PCD File No. VA265

SUNFLOWER LANDSCAPES
OFFICE / YARD
7620 MOHAWK ROAD
COLORADO SPRINGS, CO

SHEET #
L-2
© 2023 BY SUNFLOWER LANDSCAPES • ALL RIGHTS RESERVED

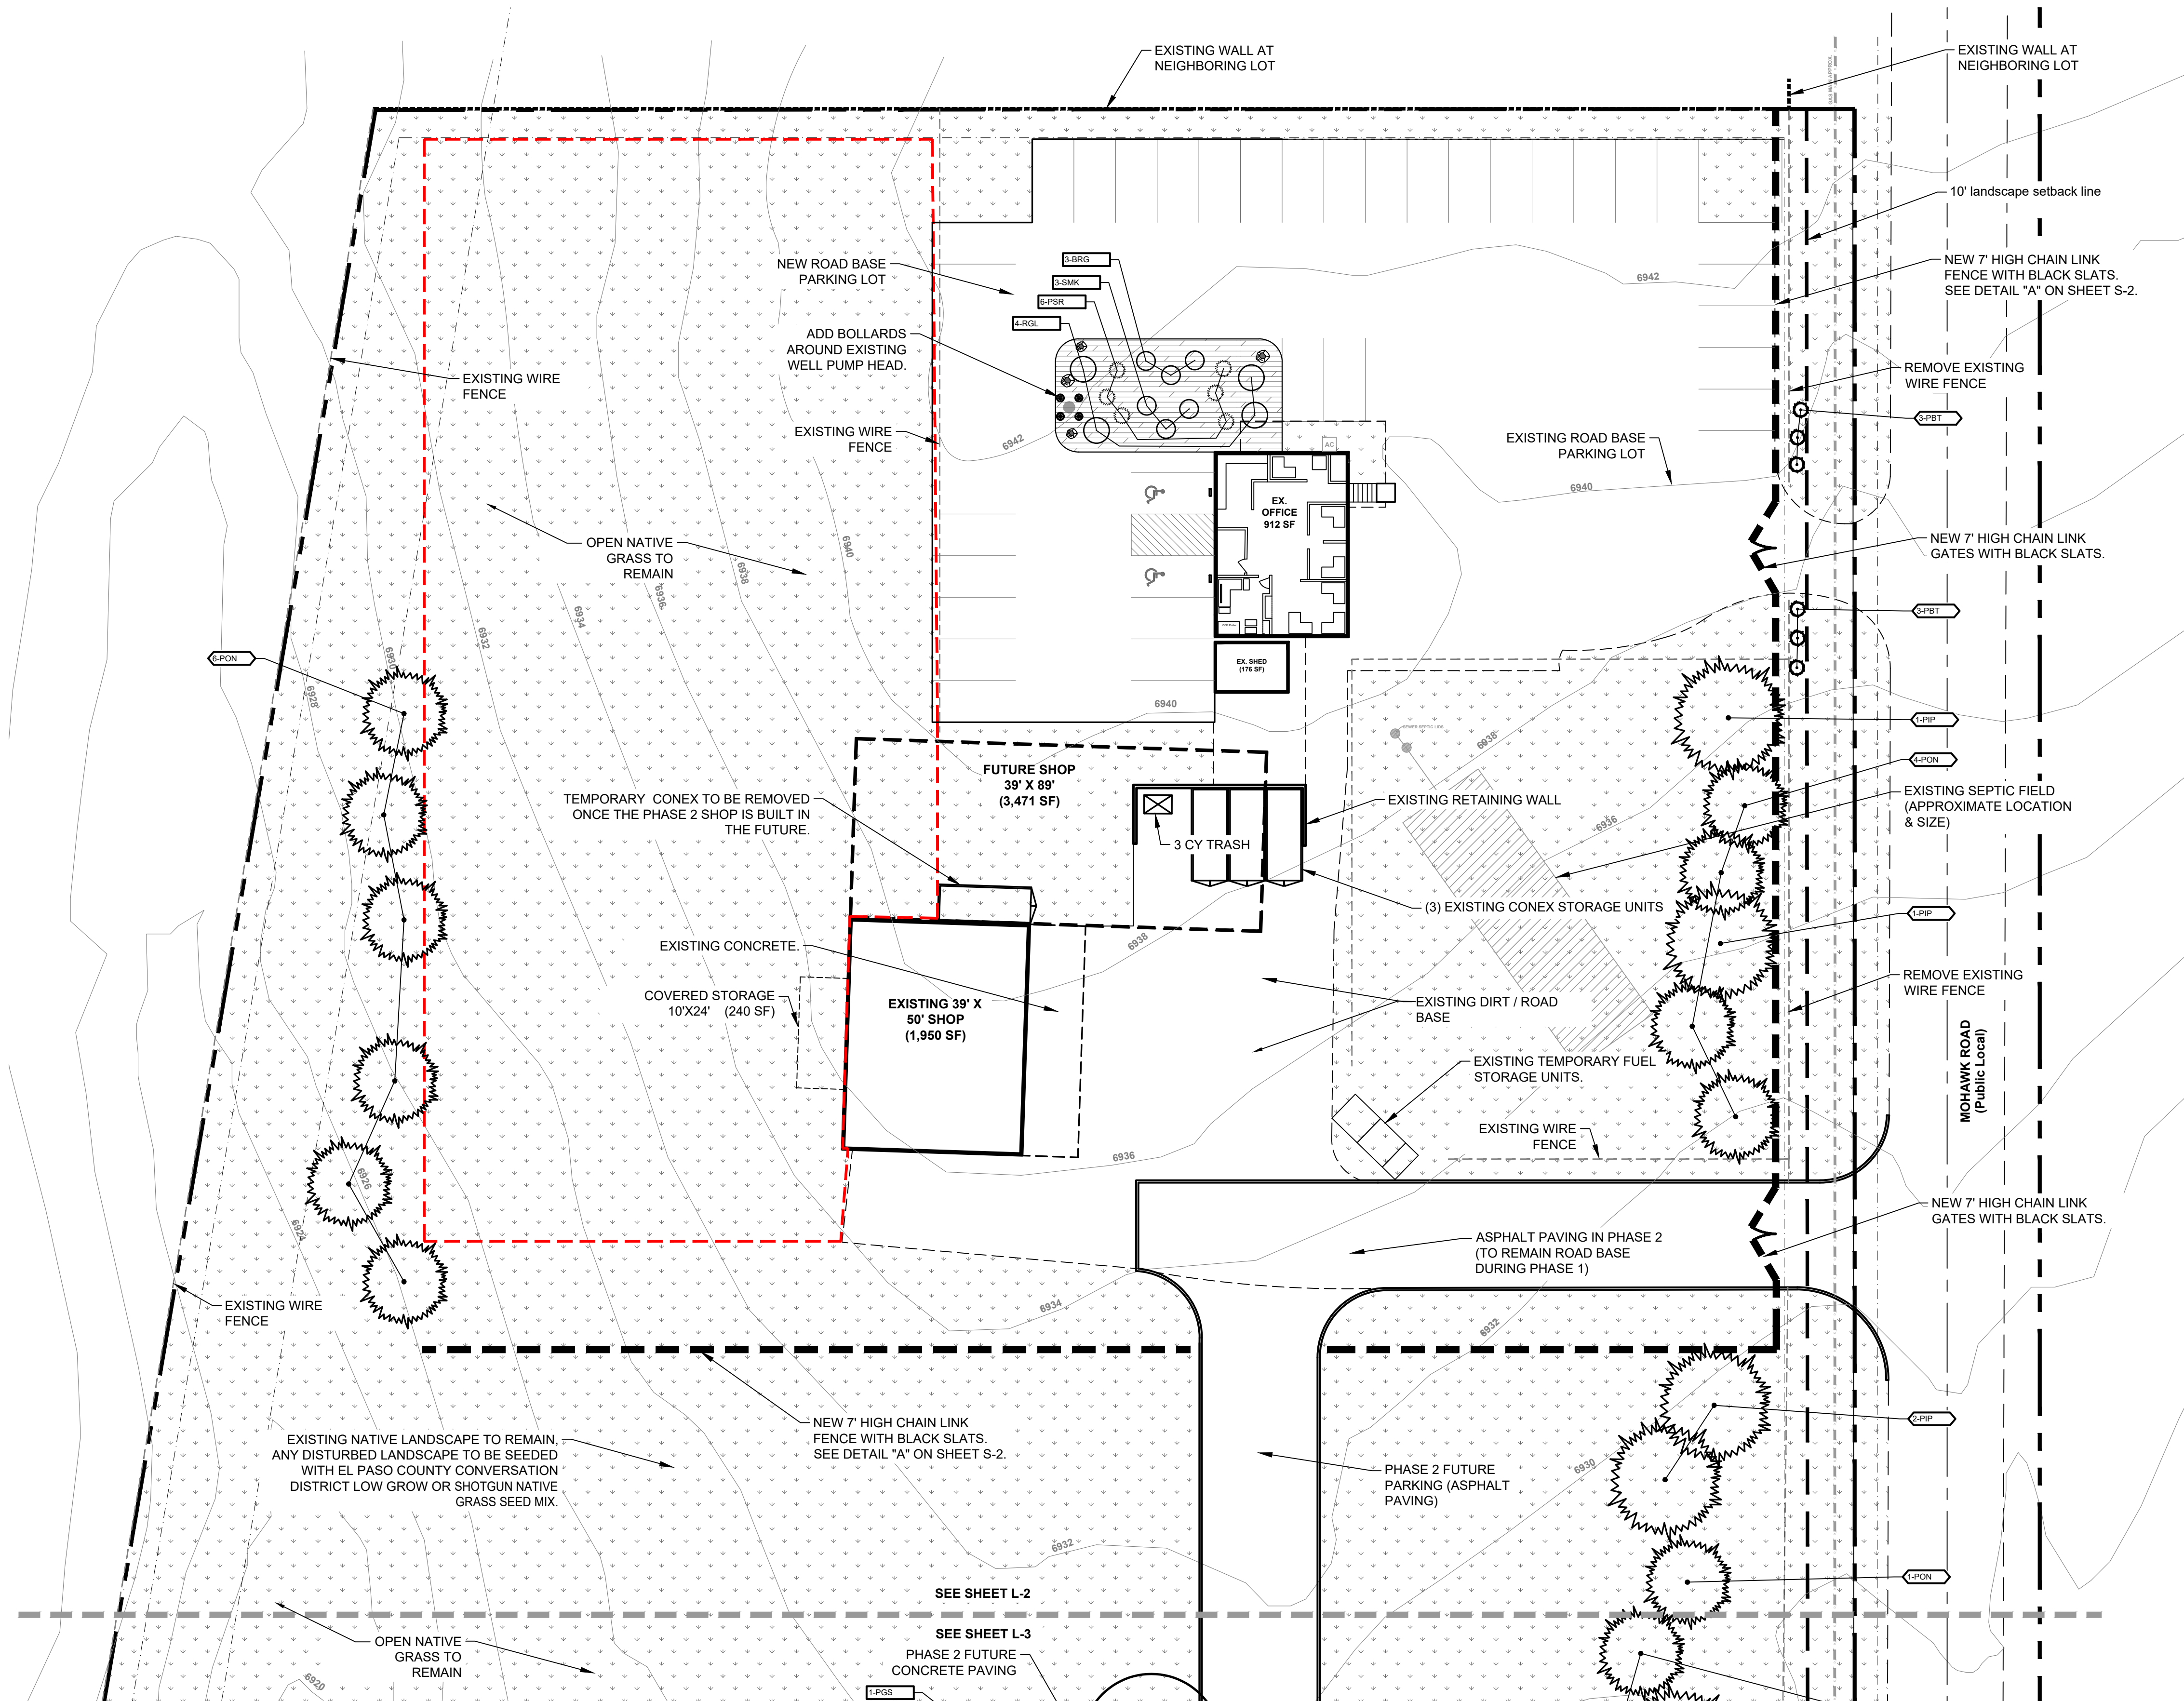
Unresolved comment. Asphalt paving is required for the first 50' in phase 1 as this access is proposed to open under phase 1. The purpose of this is to preserve the integrity at the connection with the paved county road and to track off sediment from the site before entering the ROW.

Thank you for providing the legend. Please include proposed for these since there is a mix of existing and proposed features for the site. Please match the color between the legend and the drawing.

RESPONSE: revised

RESPONSE: revised to read as this detail will be provided in the PPR and is not requiring the variance.
